## **NEWRIVER, FOUR ASHES PUBLIC HOUSE, FOUR ASHES**

### **APPLICATION BY FOUR ASHES LIMITED FOR AN ORDER GRANTING DEVELOPMENT CONSENT FOR THE WEST MIDLANDS INTERCHANGE**

### **CONNECT TECHNICAL NOTE 03 – OBJECTION ON BEHALF OF NEWRIVER TO PROPOSED RIGHT TURN BAN AT THE A449 STAFFORD ROAD / STATION ROAD JUNCTION**

**21<sup>ST</sup> AUGUST 2019**

# APPENDIX Q: TRAFFIC FLOW TURNING DIAGRAMS OF LOCAL AREA USING SSVM DATA

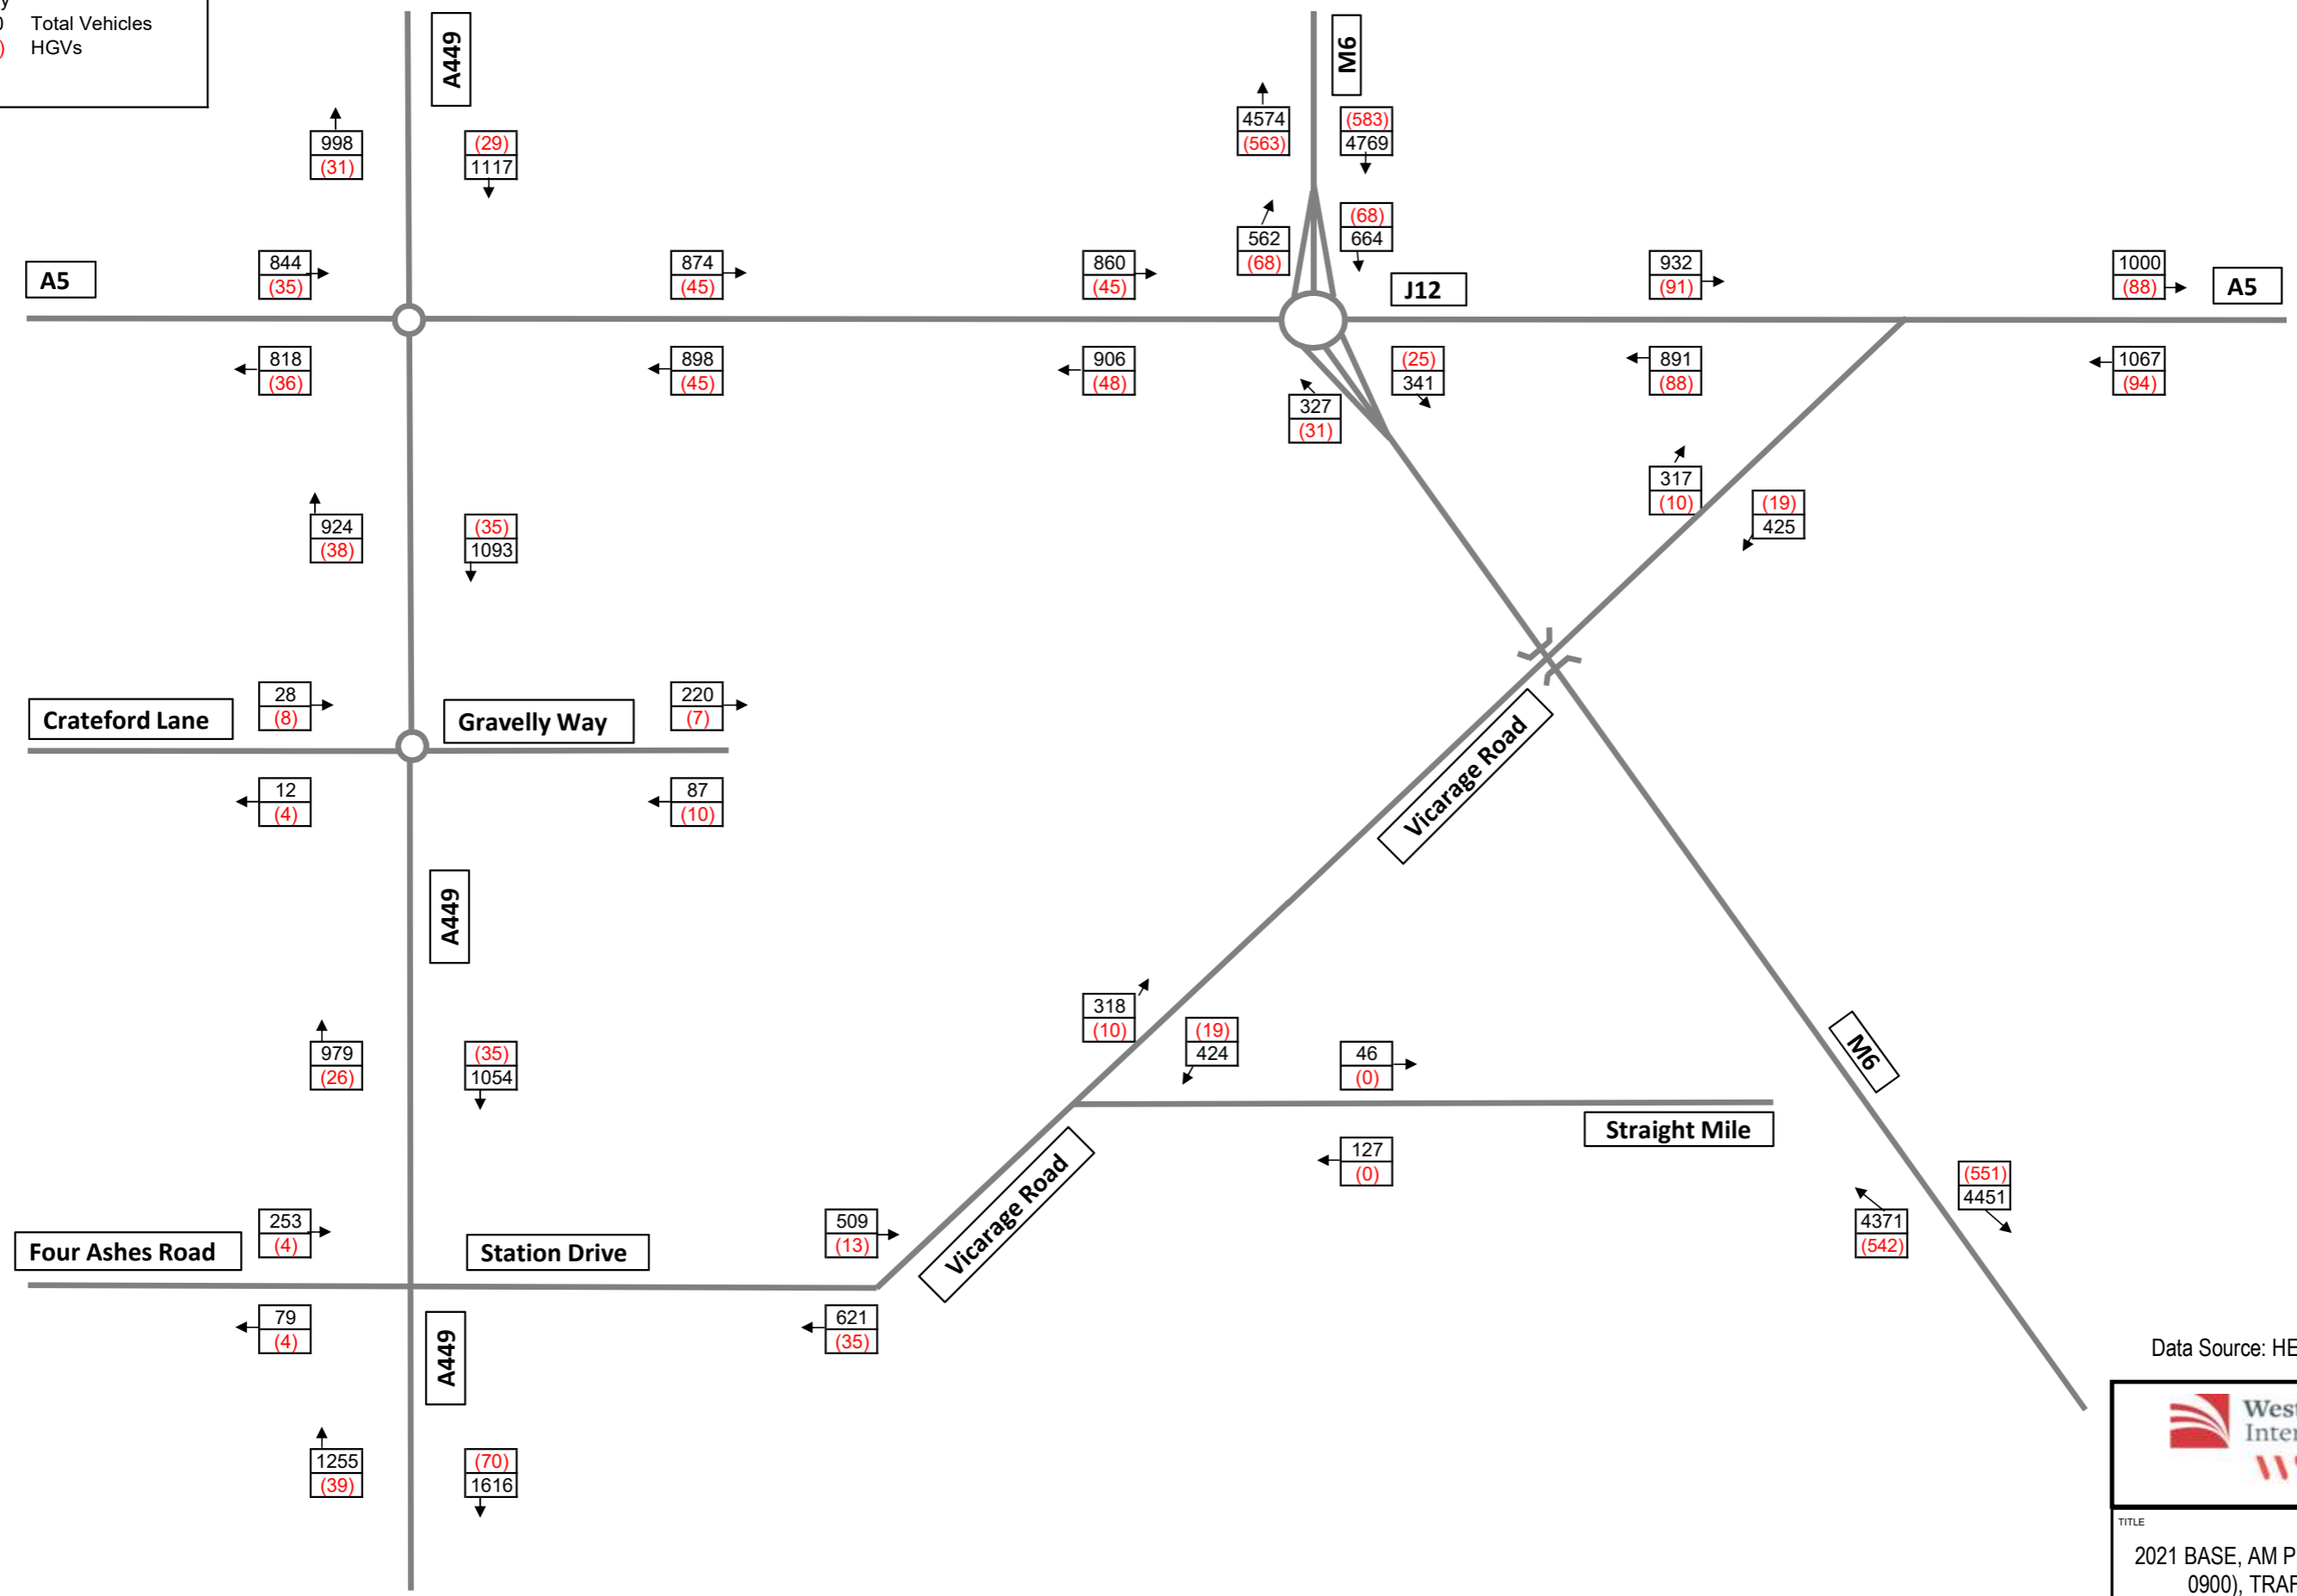
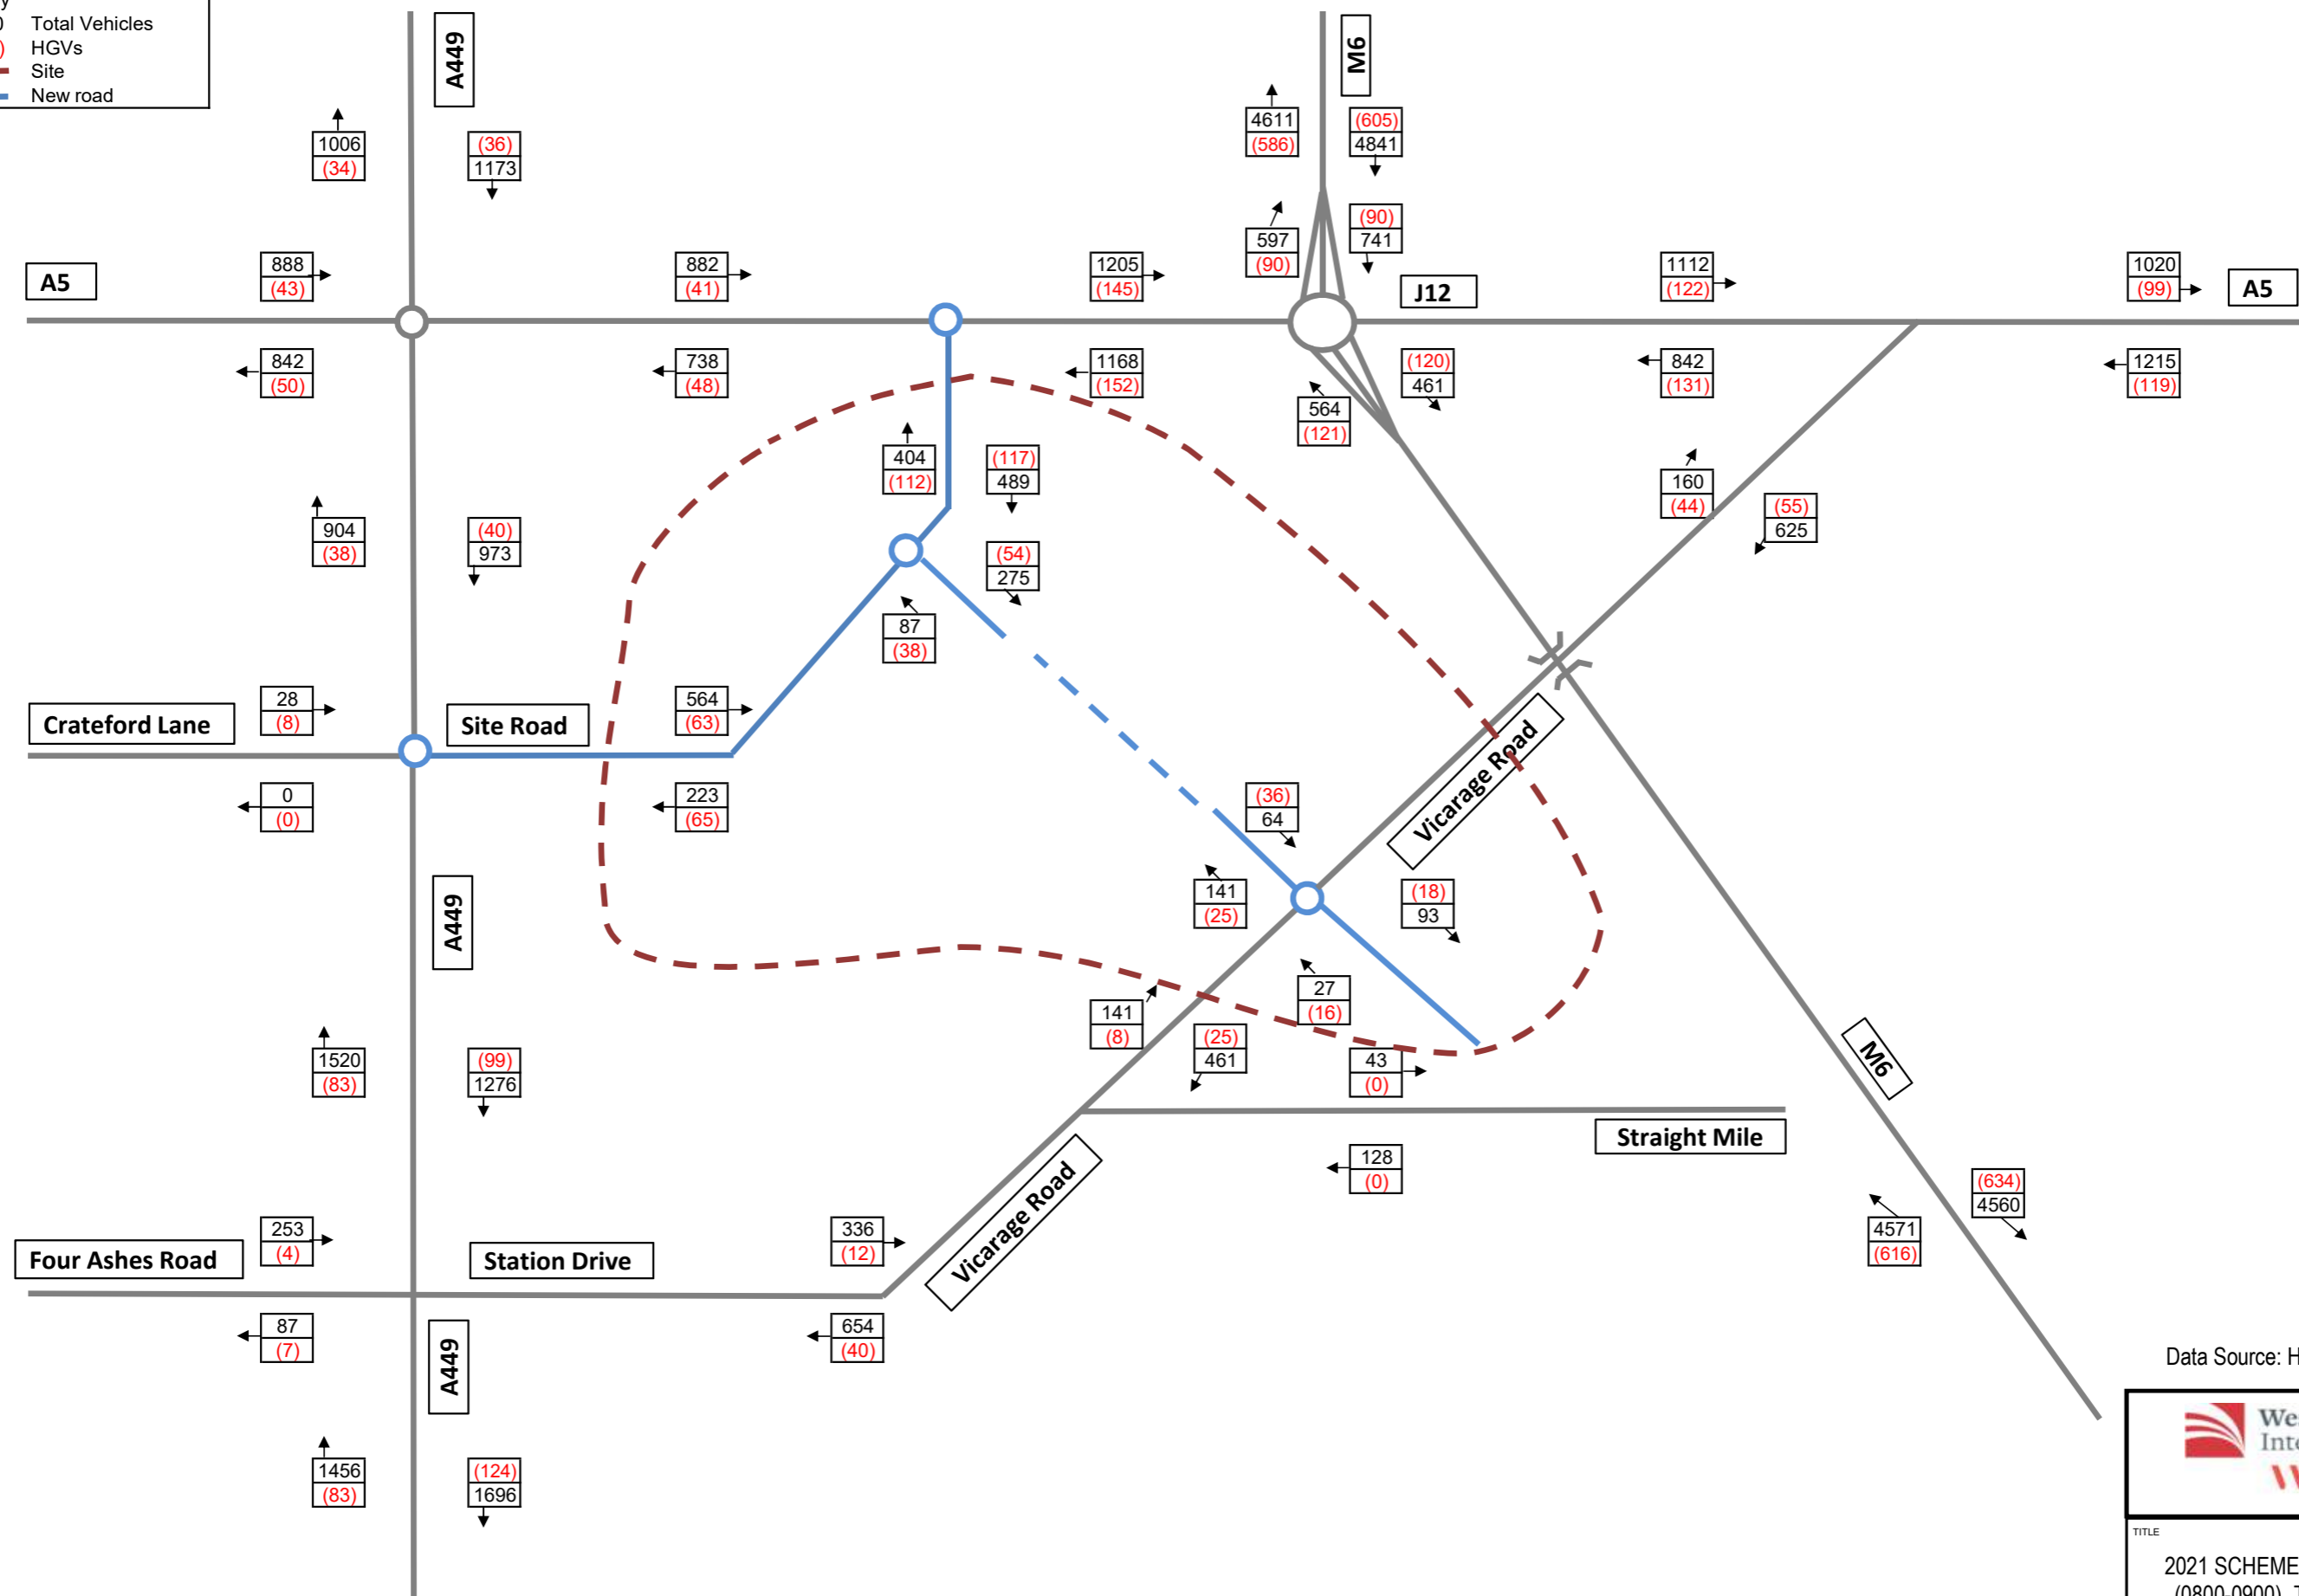
- WSP have still not presented accurate traffic flow diagrams (i.e. including U-turns at junctions) which raises questions regarding transparency.
  - Paragraph 2.5: WSP appears to be making a (diversionary) semantic argument relating to the meaning of "reduce", with the assertion that "remove" is not a subset of "reduce". This is equivalent to saying that any of the numbers one to nine are less than ten, but zero is not.
